R/191/21/HH

R/192/21/L

Existing Elevations

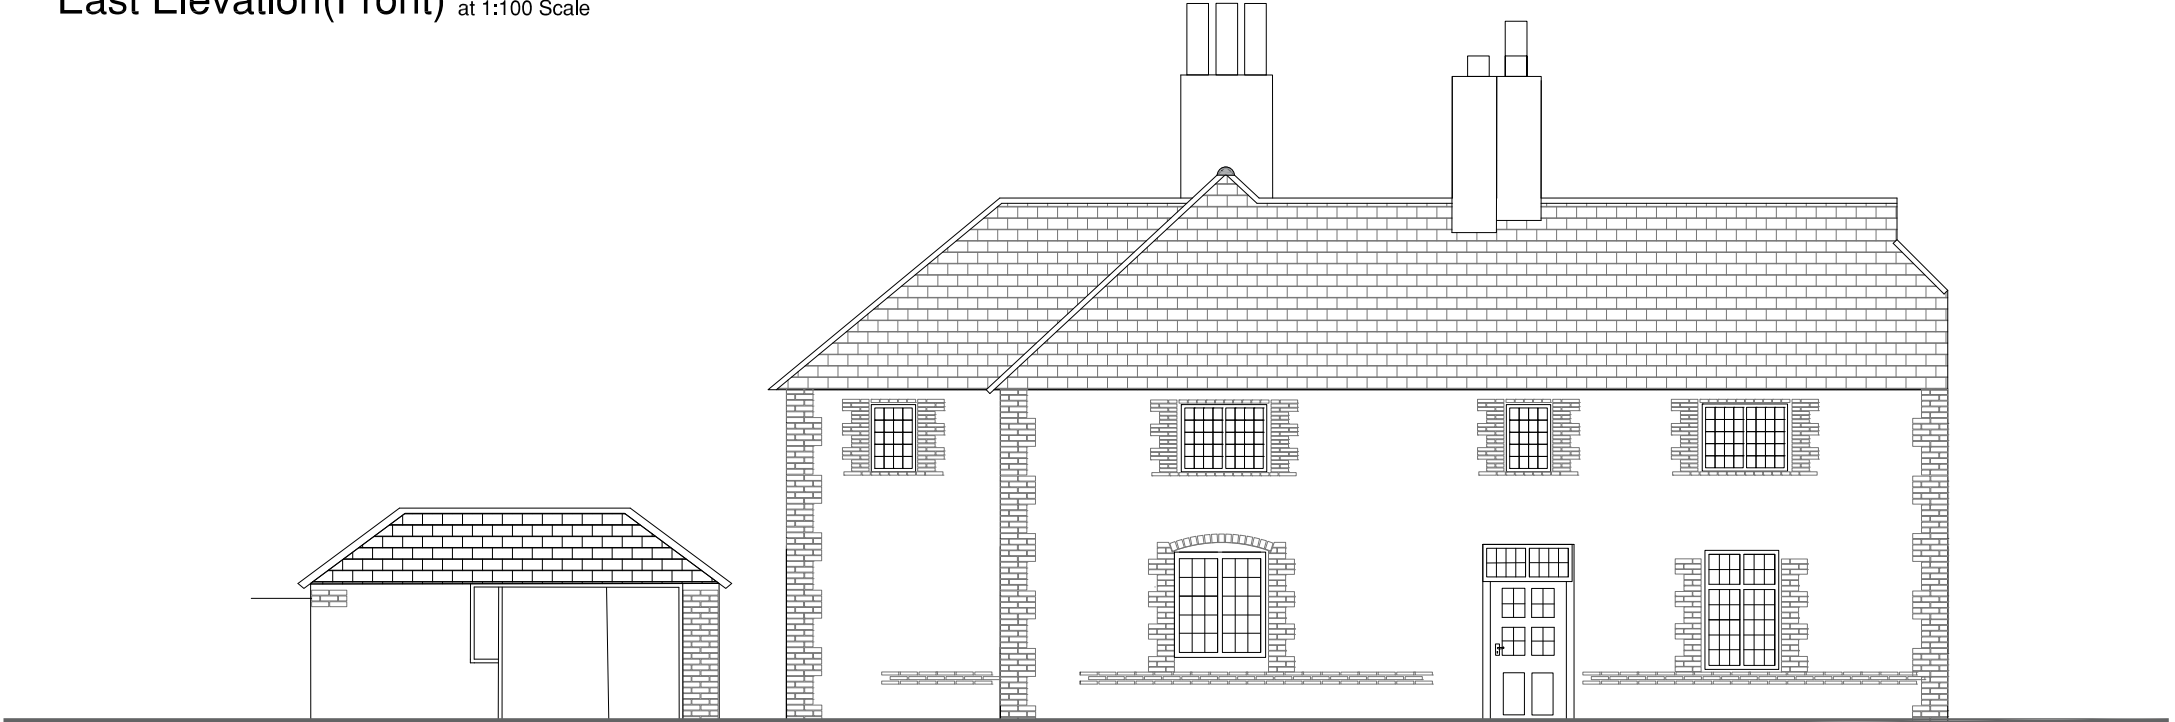
The windows on the existing front and side (south) elevations are inconsistent with the windows on the existing first floor plan. Please review and amend

Drawing: Proposed Elevations

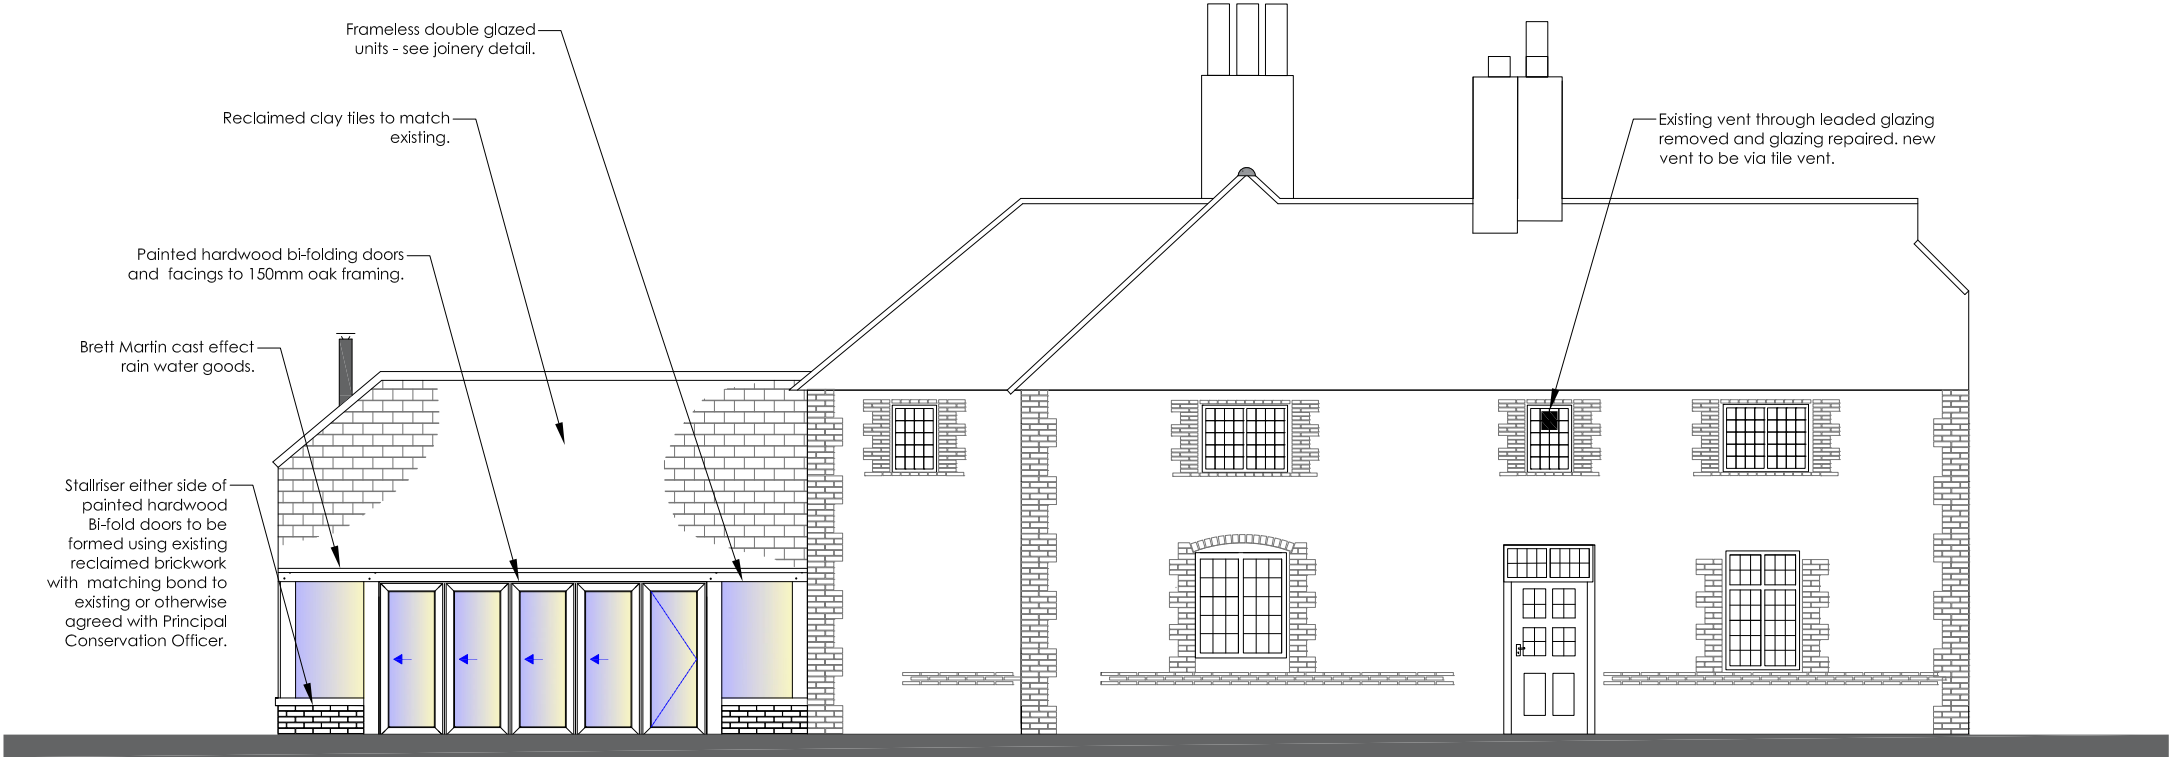
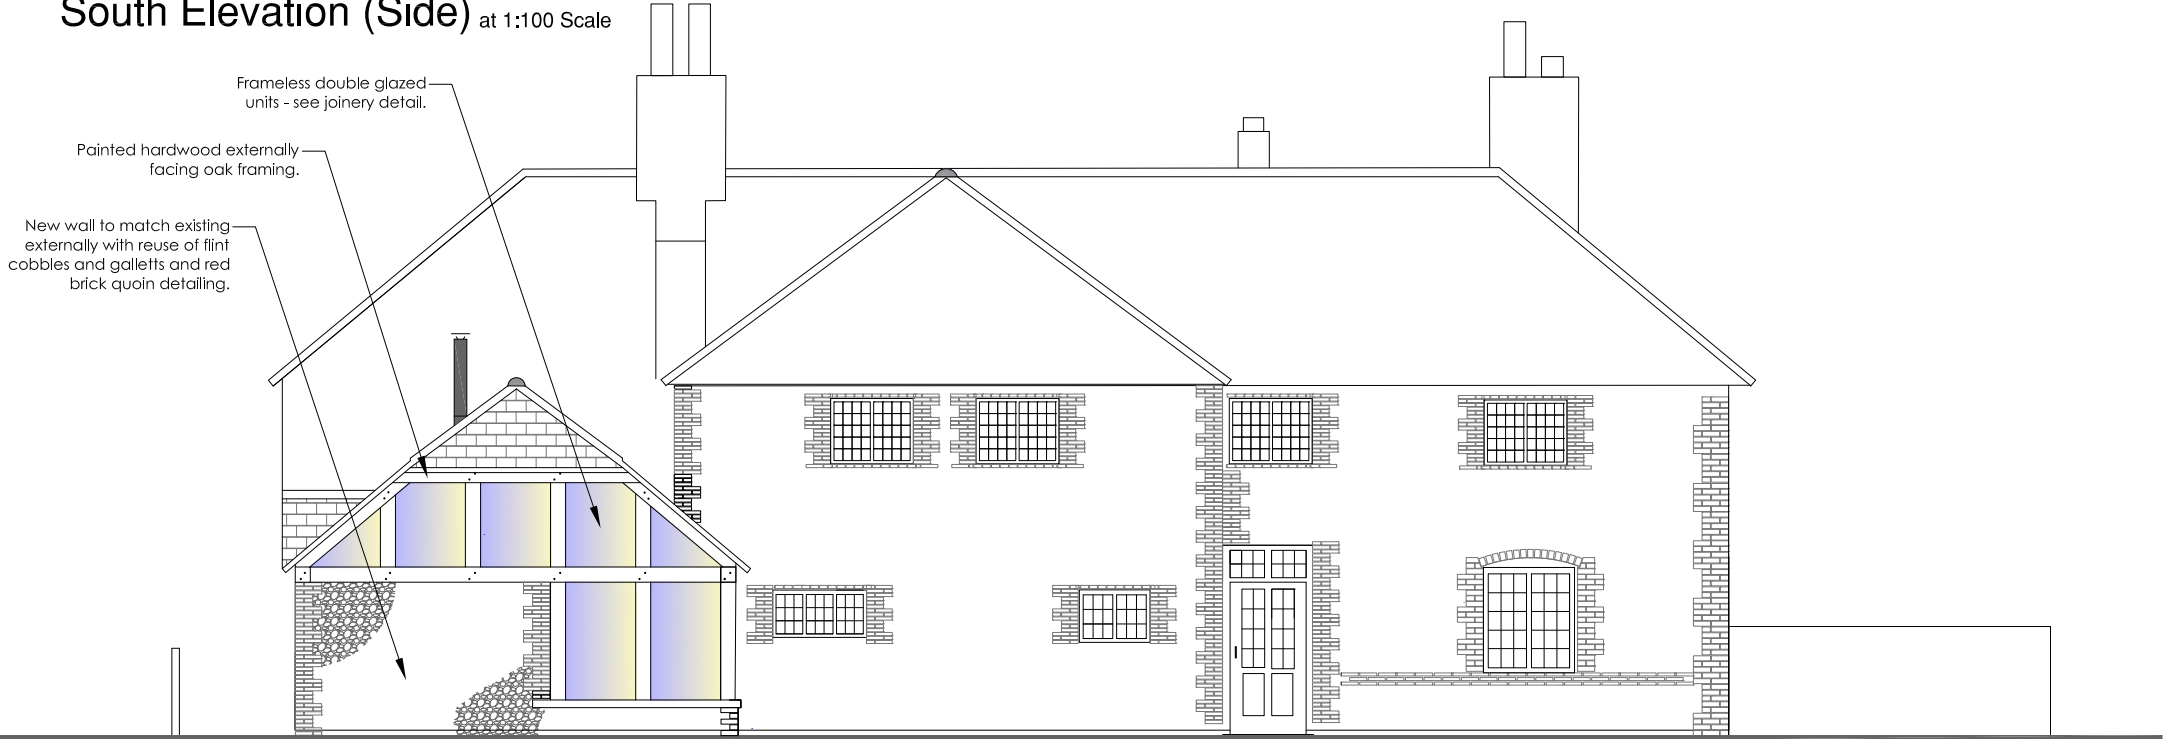
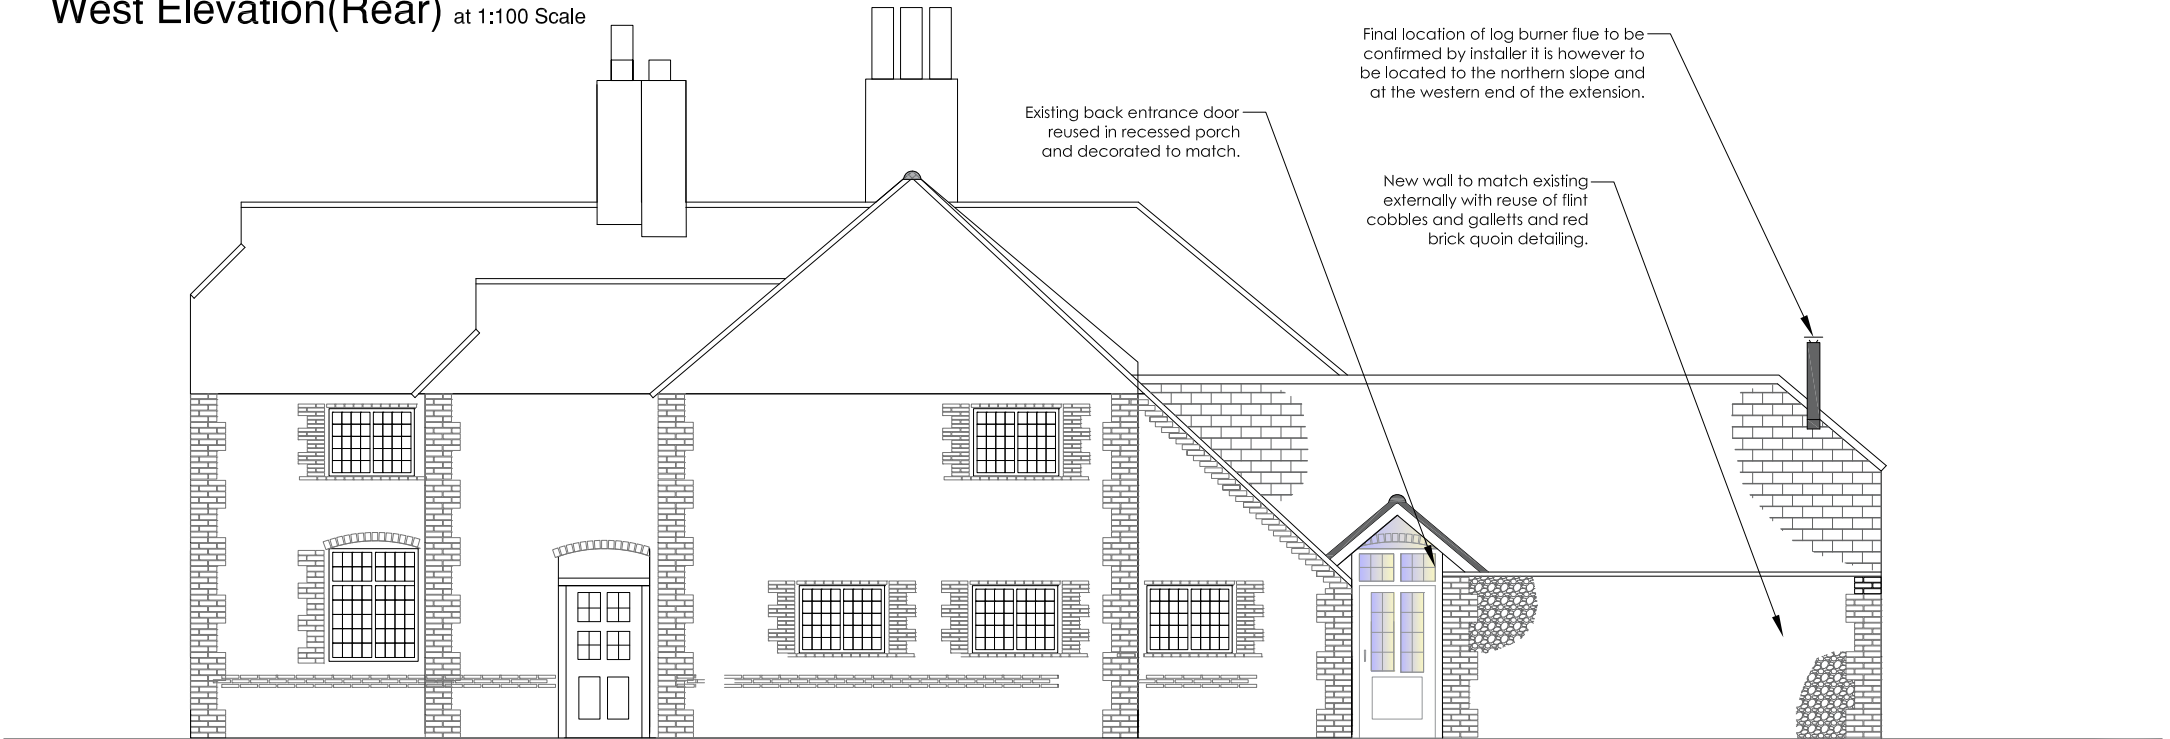
The proposed south (side) elevation is inconsistent with the proposed ground and first floor plan. Please review and amend.

The windows on the proposed south (side) elevation are inconsistent with the proposed first floor plan. Please review and amend.

The proposed south (side) elevation is inconsistent with the proposed ground and first floor plan. Please review and amend.

As per our discussion, just the first floor plan and relates to the above.

As per our discussion as above.

As per our discussion as above.
